Royal Randwick Racecourse
Proposed Hotel, Access, Parking and Bus Access Information

This letter has been prepared to address the issues highlighted by Department of Planning (DoP) and the Roads and Maritime Authority (RMS) in relation to the proposed Hotel development within the Royal Randwick Racecourse site. The ATC and PTC presented the proposal and the following responses to DoP and RMS on 8 November as a powerpoint presentation, which provided the opportunity for all present to discuss the proposal and ideas/comments that the design team could consider.

DATE: 10/07/12

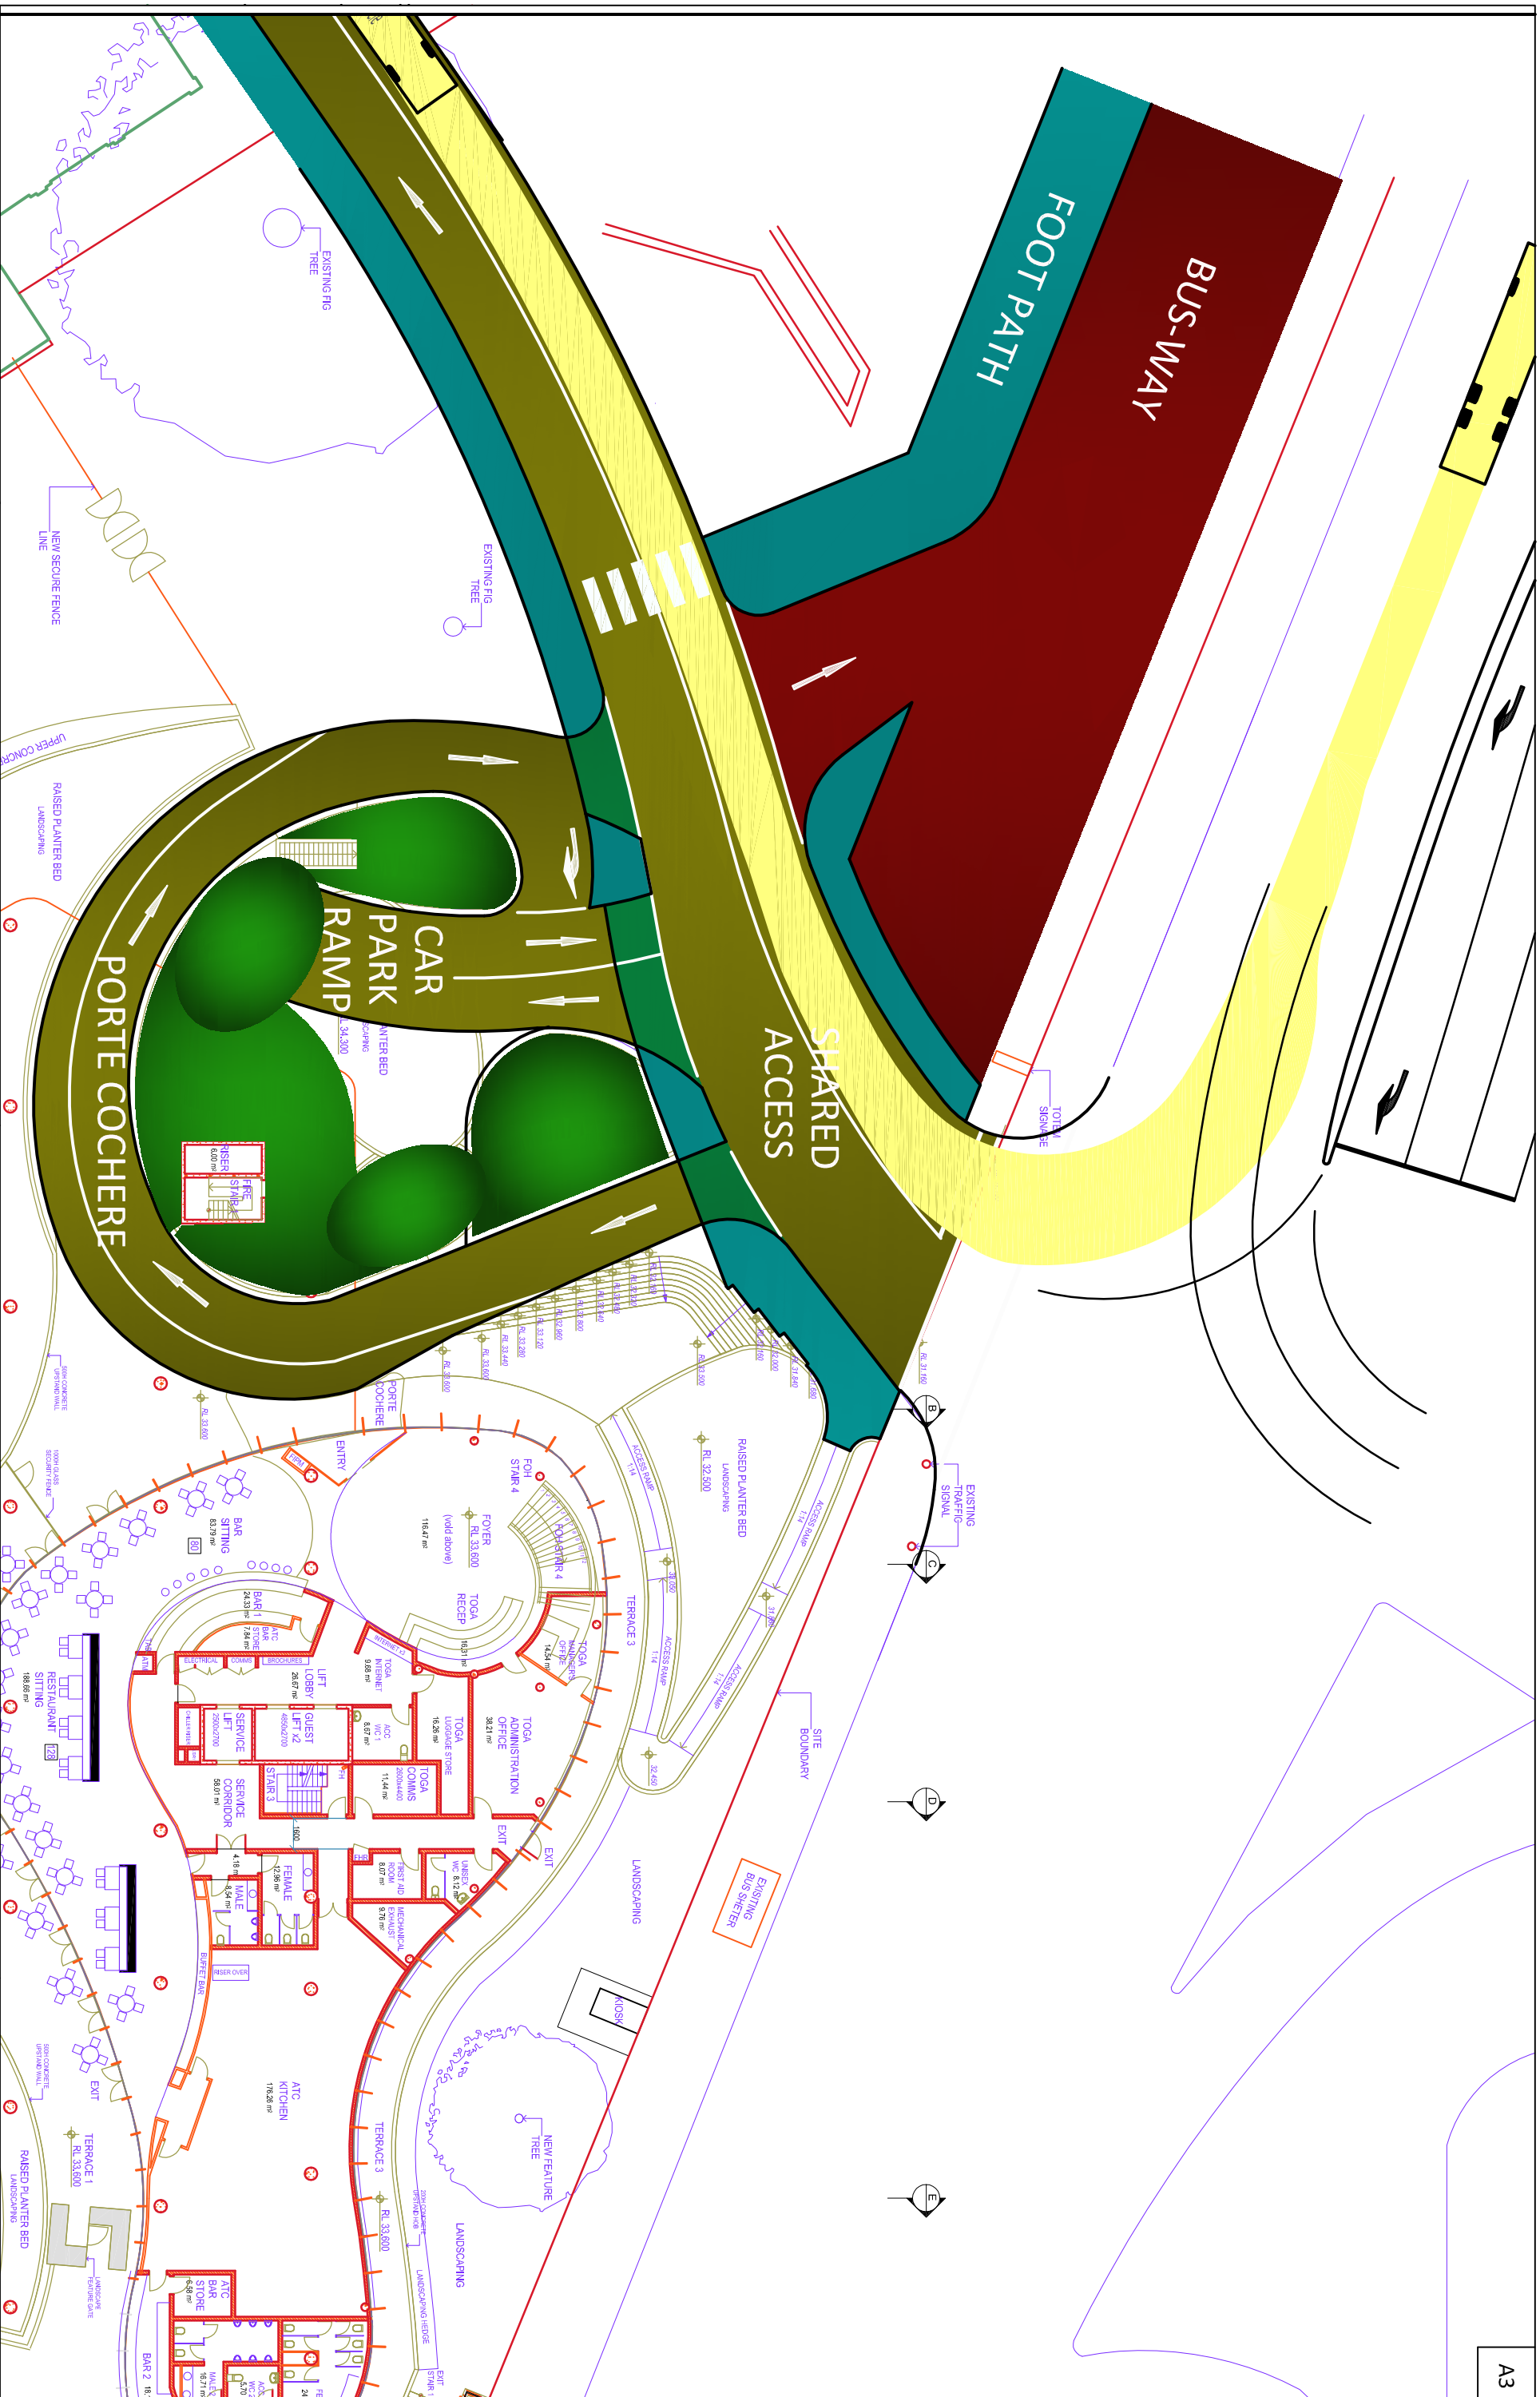
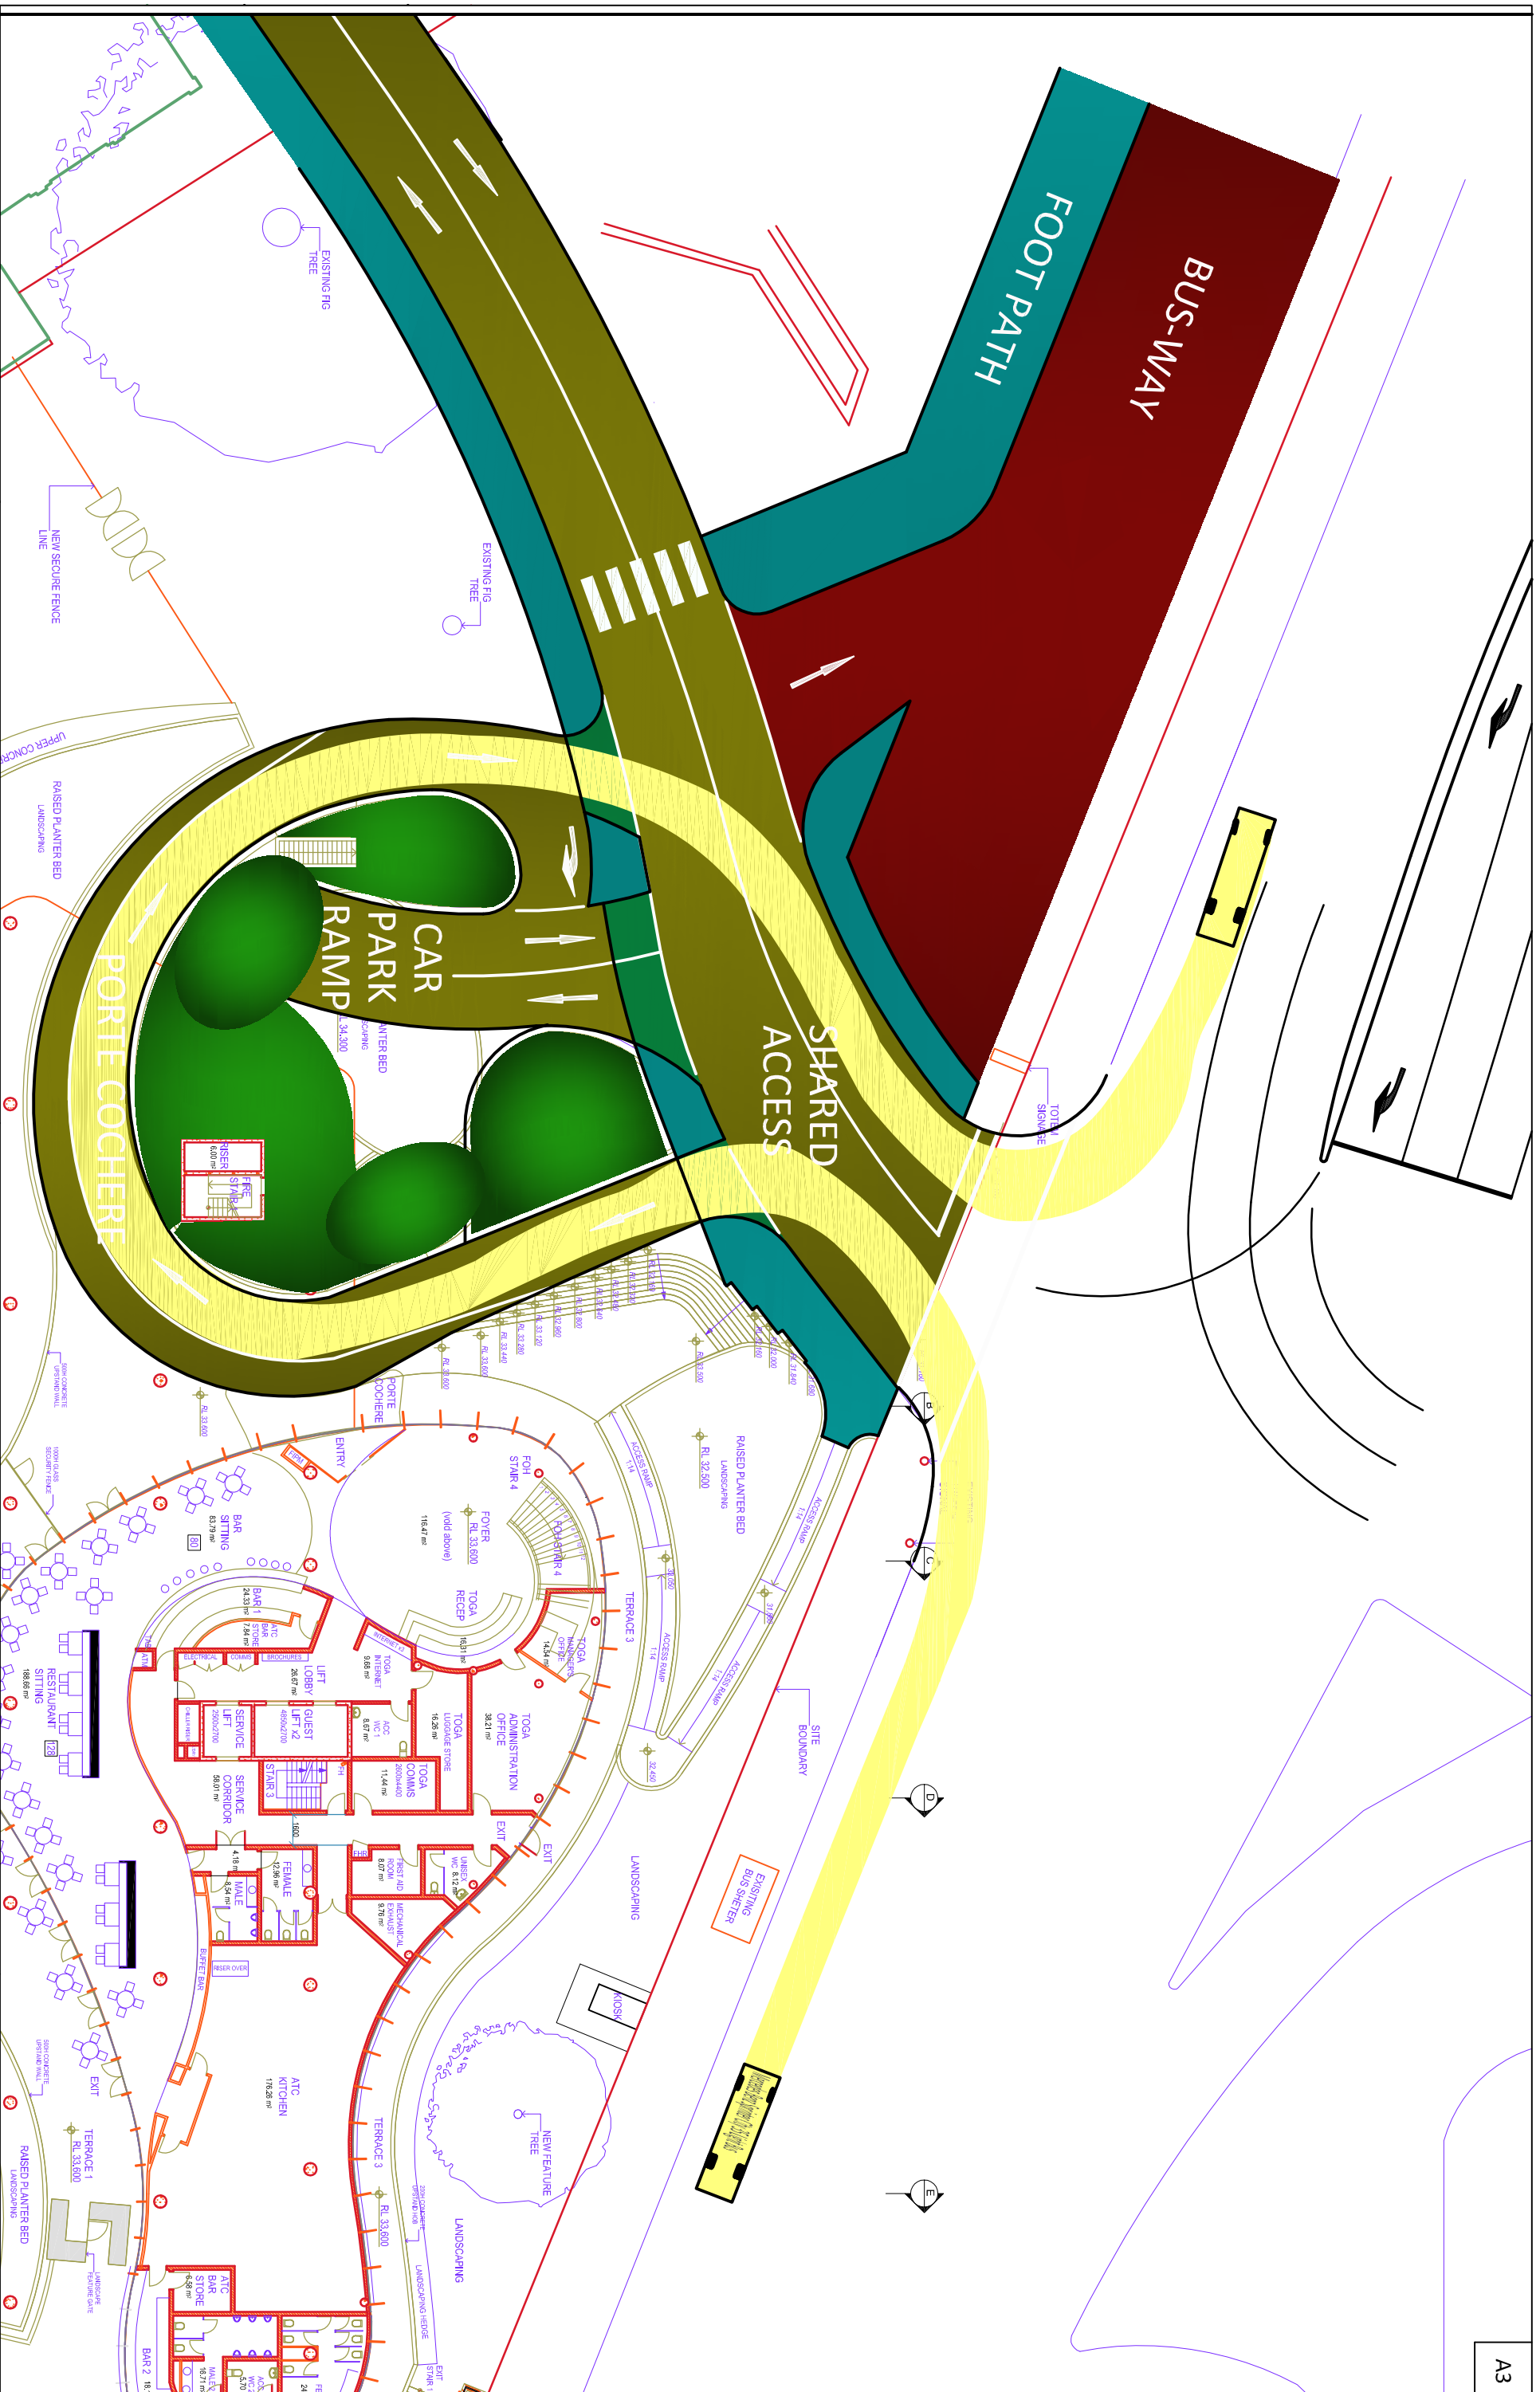
The proposed right turn into the site from Alison Road is not supported due to potential negative impacts on the surrounding road network and bus operations. An alternate arrangement should be considered to accommodate expected additional traffic without impacting on the existing road network. Any proposed alternate access arrangement should be supported by details of any SIDRA Modelling used, scaled plans illustrating adequate lane widths and vehicle turning circle into the site.

In conjunction with the traffic assessment submitted with the Development Application, a SIDRA analysis was prepared in order to determine the operation of the intersection before and after the hotel development. The modelling confirms that the 95th percentile queue for the site access right turn was 0.7 vehicles during the morning peak and 0.5 vehicles during the evening peak, indicating the proposed right turn lane length of 25 metres (excluding taper). The length of the right turn lane is sufficient to accommodate the queuing expected during normal operation, but will accommodate two 12.5 metre long

buses when in use in relation to the bus-way. We have prepared microsimulation modelling, which demonstrates that no more than two buses arrived at one time over the period of the modelling. This was based on the peak bus volume (26 buses in 1 hour) superimposed over the peak traffic volumes associated with the Epsom Super Saturday. To provide a sensitivity test, we then doubled the number of buses, which indicates that up 58 buses per hour can arrive via the intersection with no more than 2 buses being queued. The management of bus arrivals is also an important aspect of the proposed arrangement, which is discussed in detail further below.

Swept paths are shown as **Attachment A**, demonstrating that all movements can be undertaken by the appropriate vehicles, including the right turn from Darley Road by a bus in the outside lane, along with two cars in the inside lanes.
